Your ref: SSD-76555711
Our ref: DOC25/501541

Subject: Major Projects - Response to Submissions (RTS) - Mixed use with infill affordable housing (SSD-76555711) (Willoughby City)

Thank you for your email dated 23 September 2025 seeking advice from the Conservation Programs, Heritage and Regulation (CPHR) group of the NSW Department of Climate Change, Energy, the Environment and Water (DCCEEW) on the State significant development application (SSD-76555711) located at 3-5 Help Street, Chatswood.

Flood Risk Assessment

**PROJECT:**  
DETAIL AND LEVEL SURVEY OF SP134 & SP52320

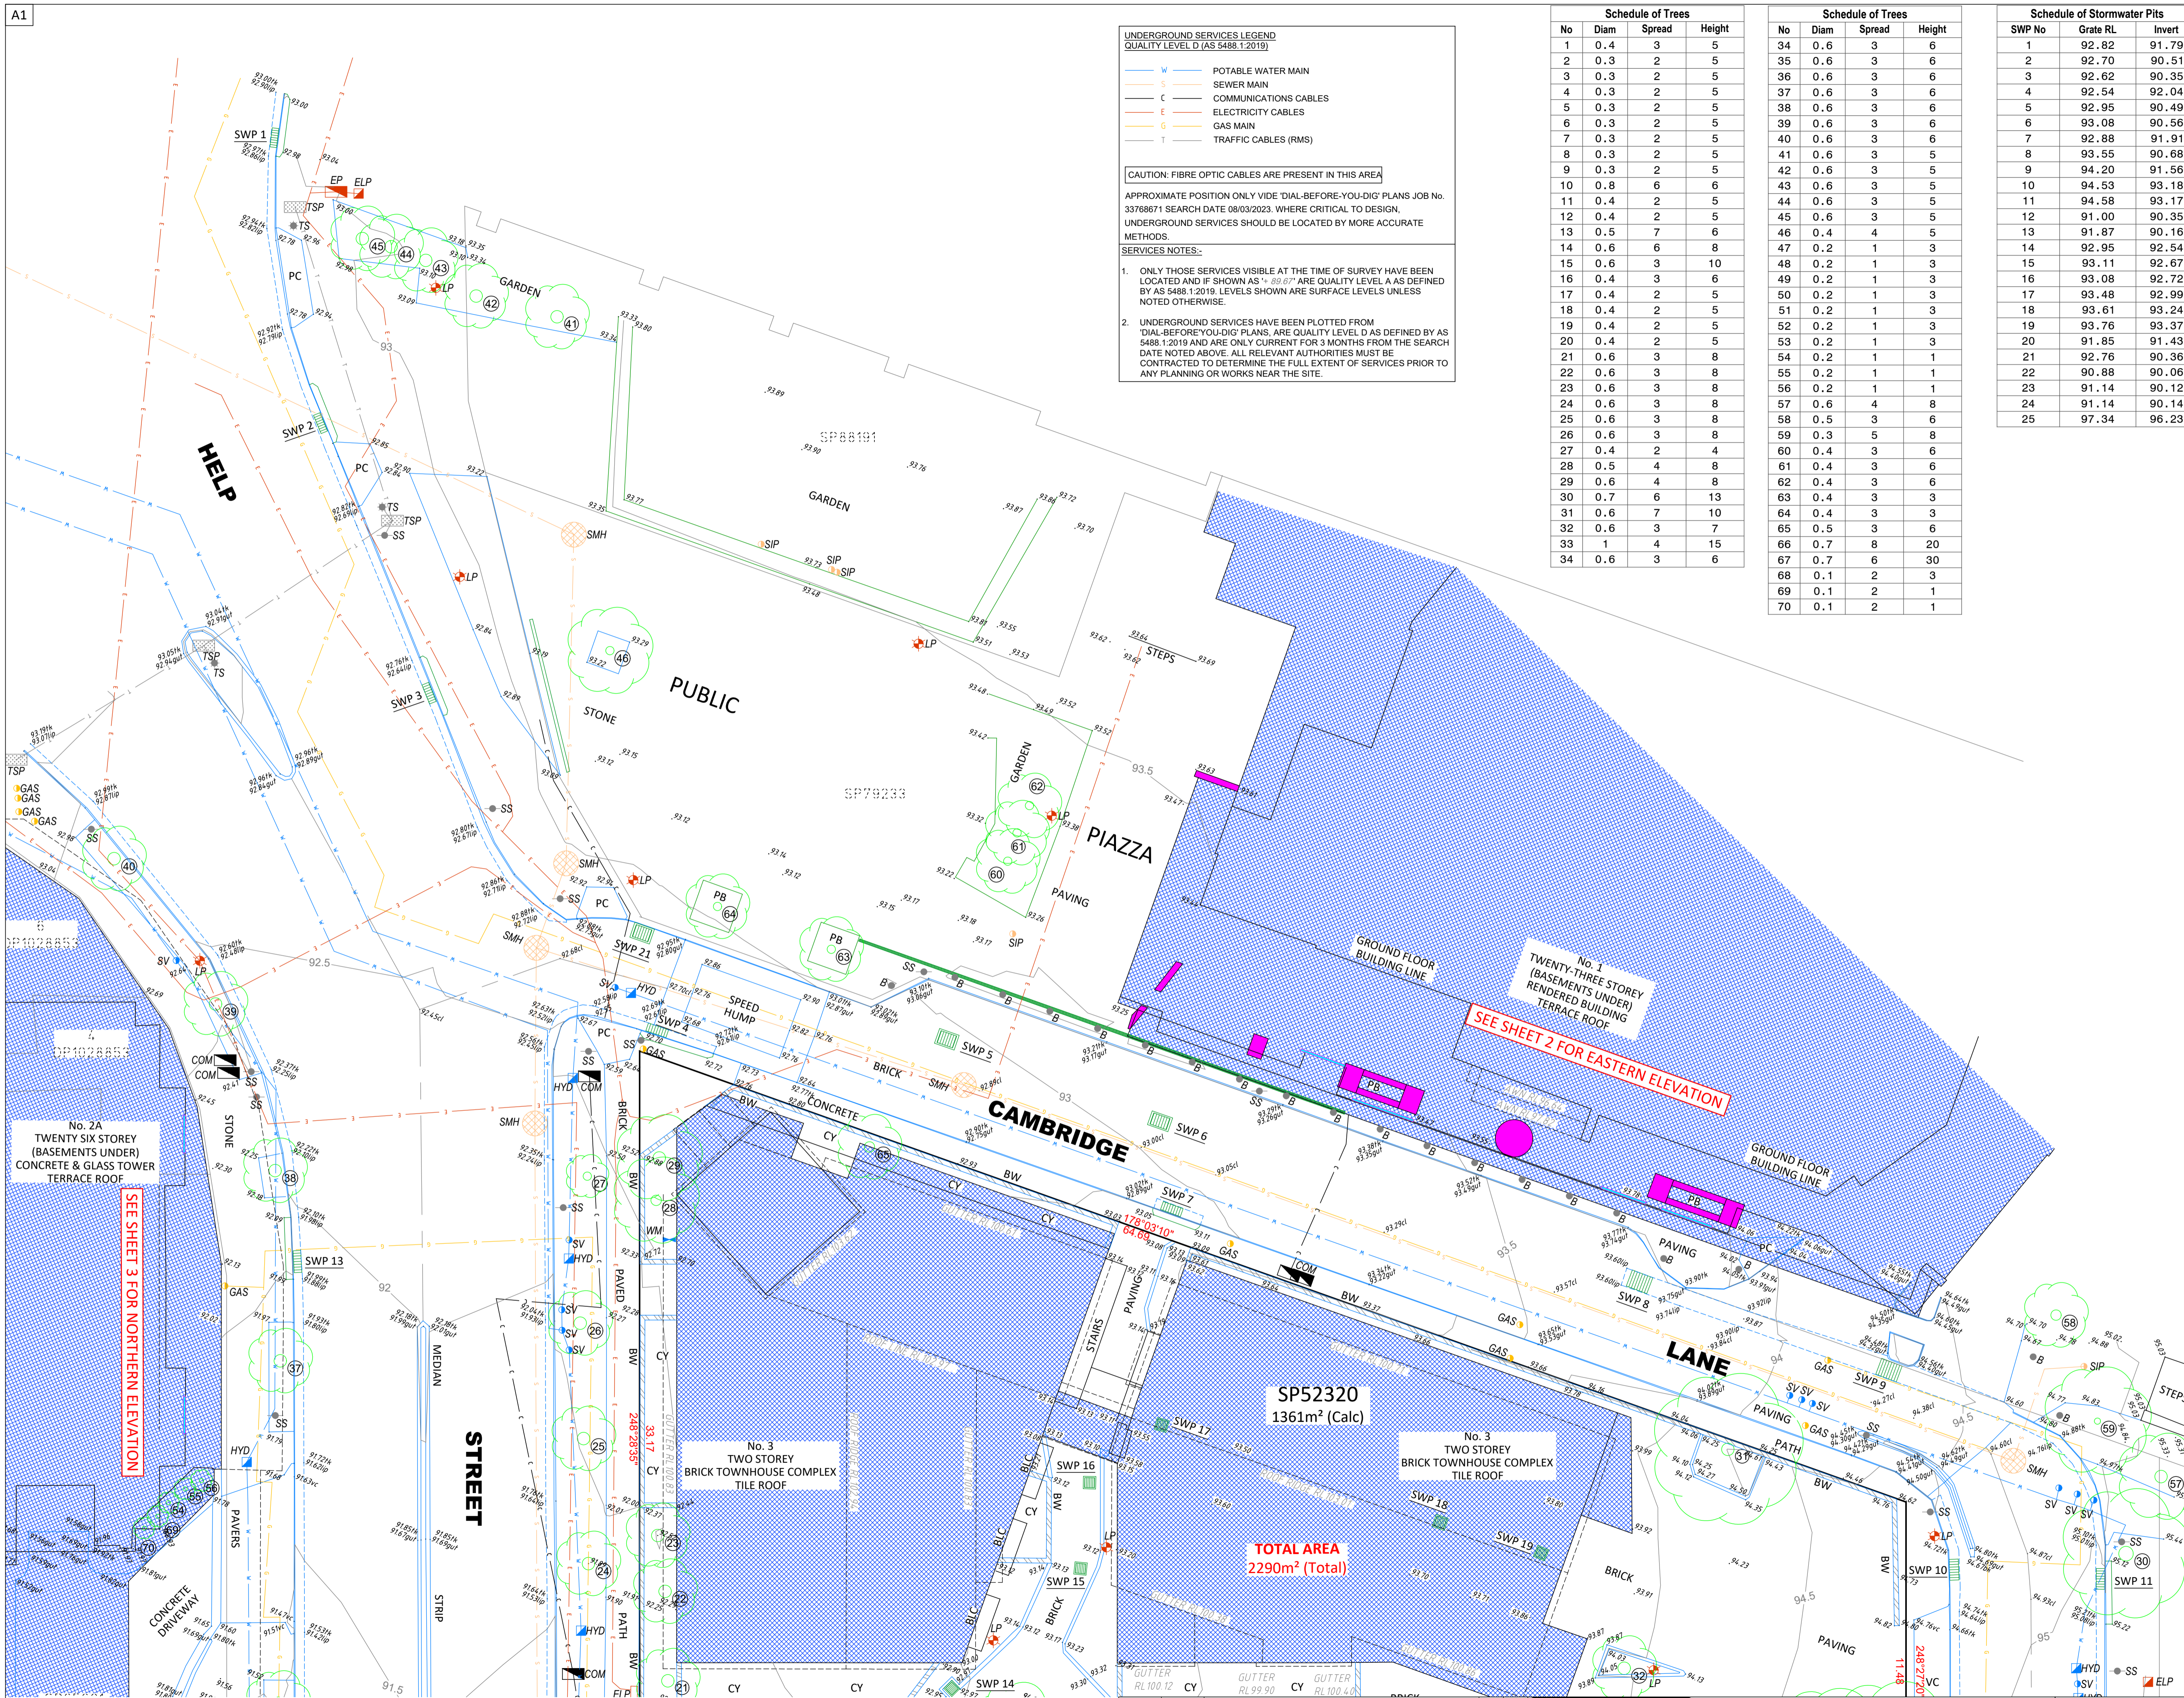
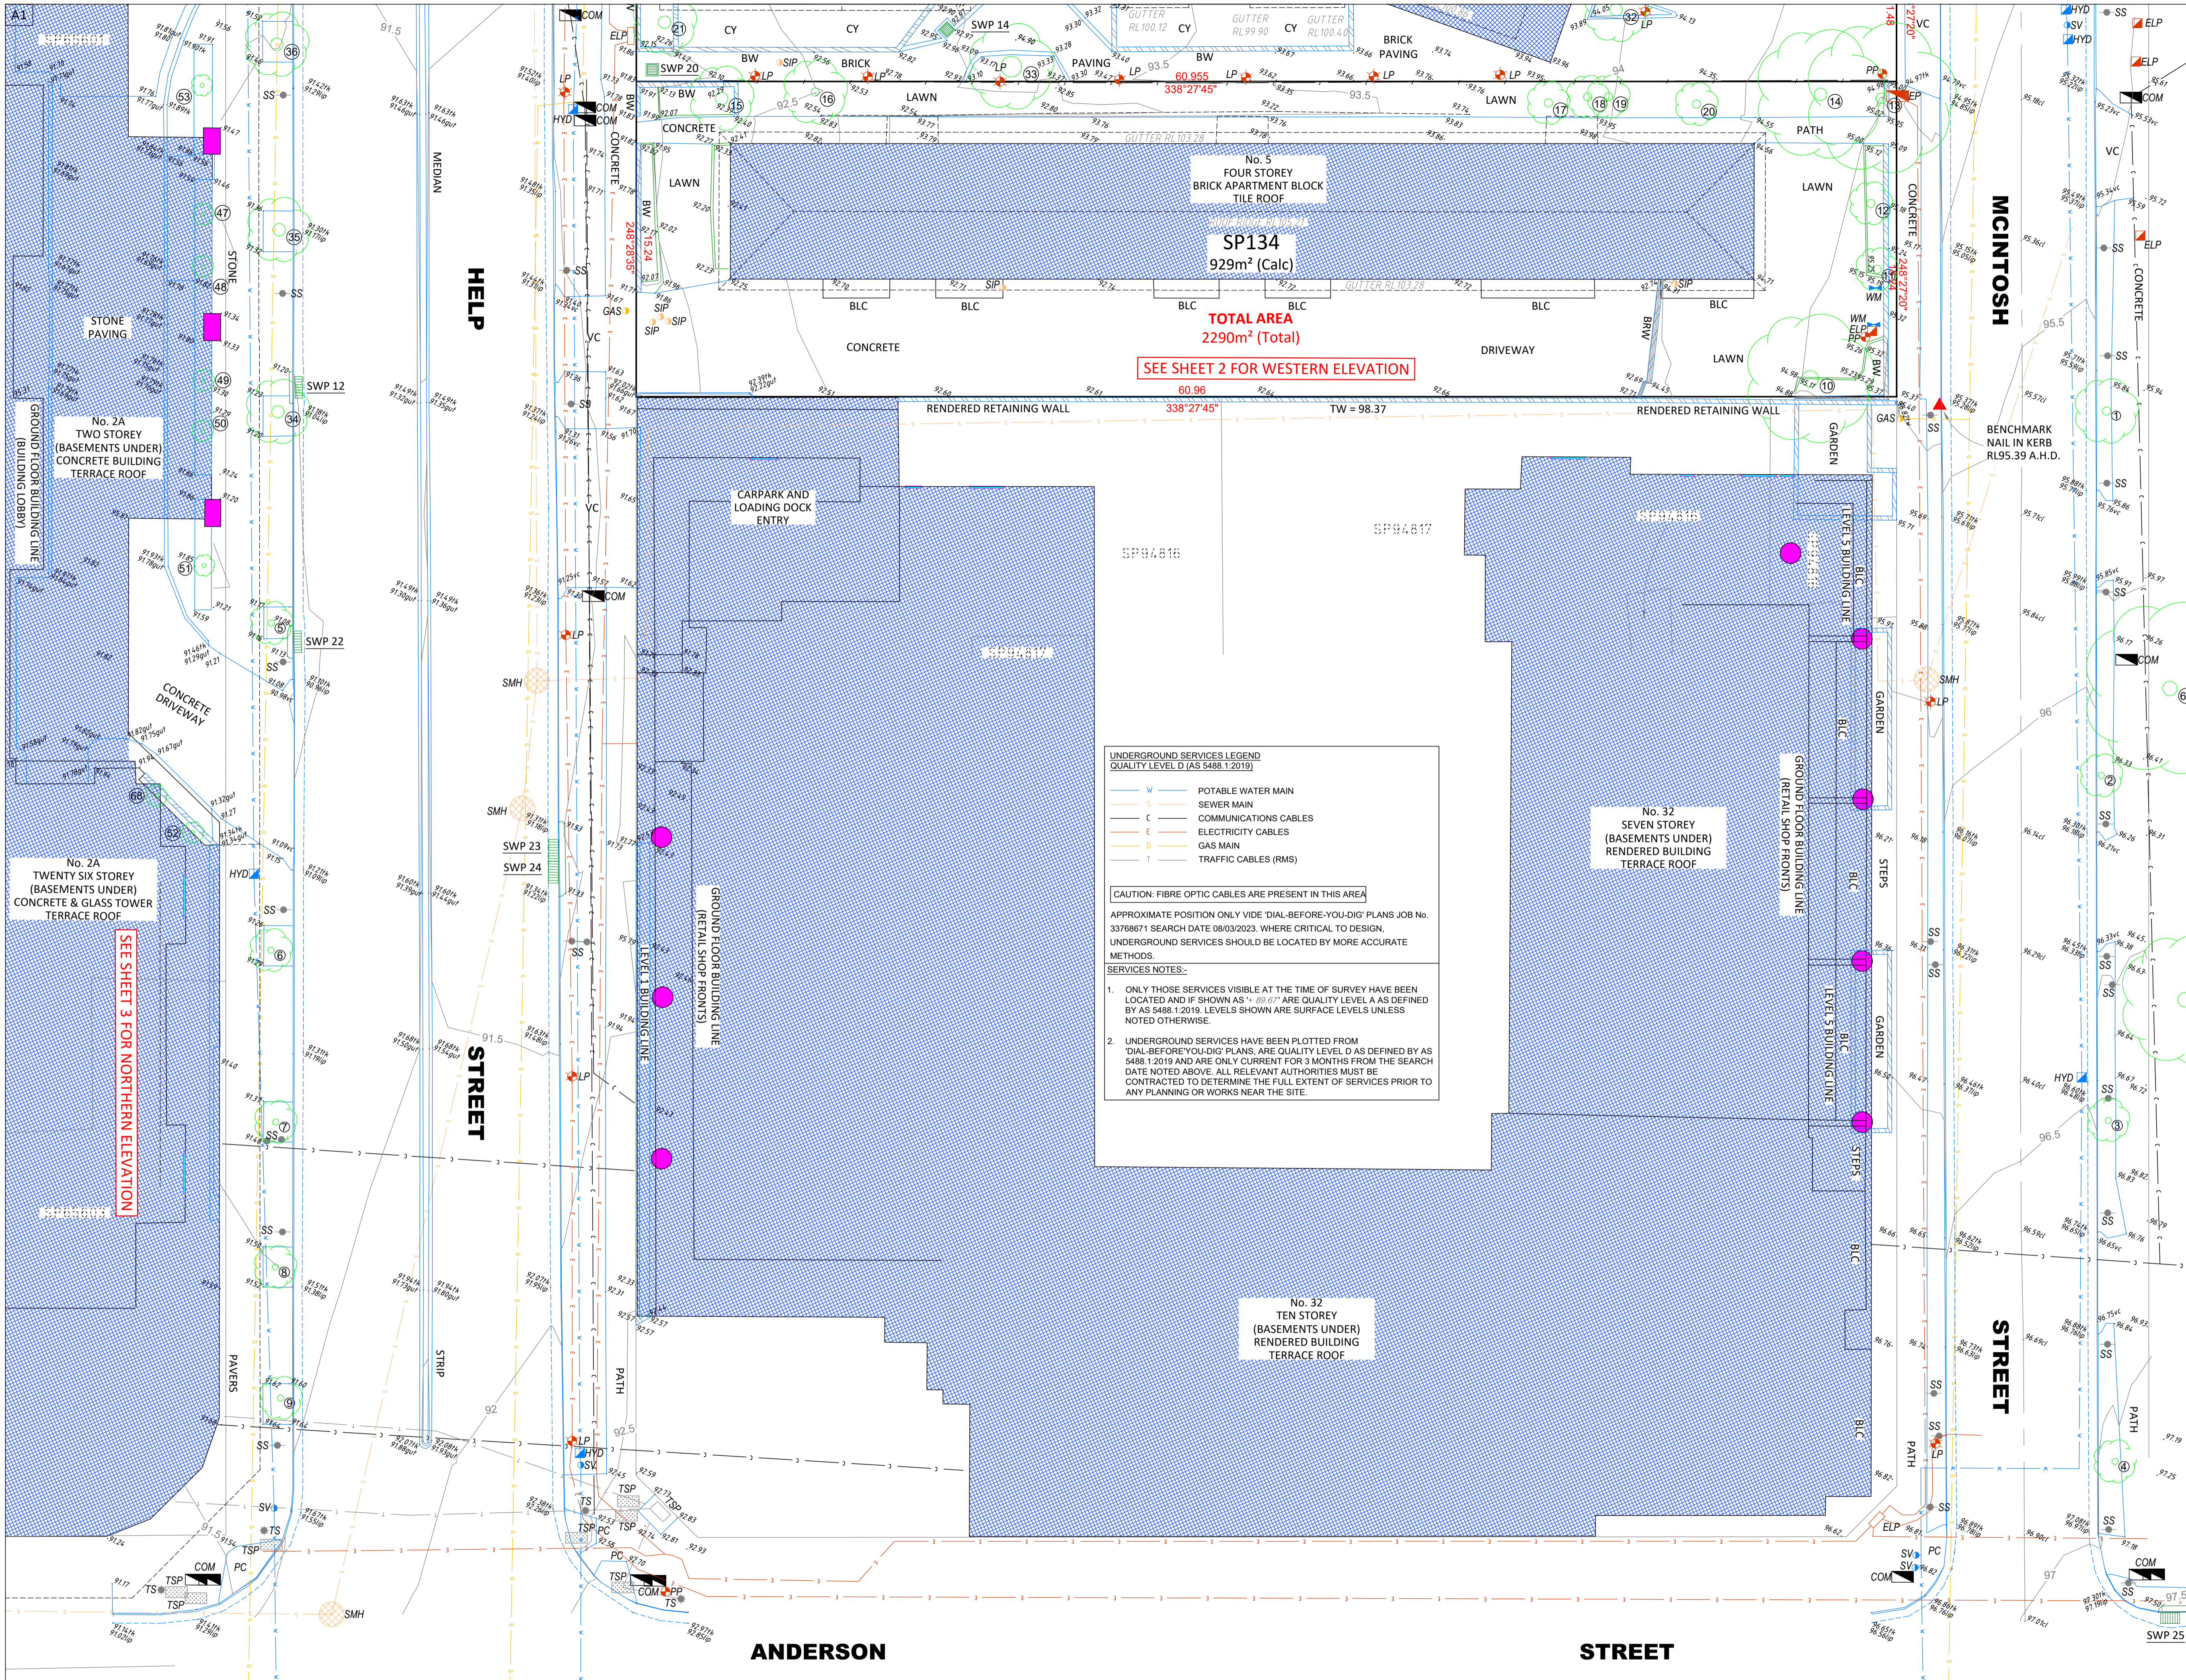
The flood report previously provided by Stantec estimated a PMF level of 93.54m AHD in the sag point in Help Street. If the water was able to escape via the Anderson Street corner, then the flood report should have been able to confirm this by modelling. The survey in the civil drawing set does not show levels for the full extent of Help Street however levels of at least 91.8m are shown in the truncated survey and this is higher than the 91.6m reported by the flood consultant. CPHR does not agree with these assurances made in the RTS.
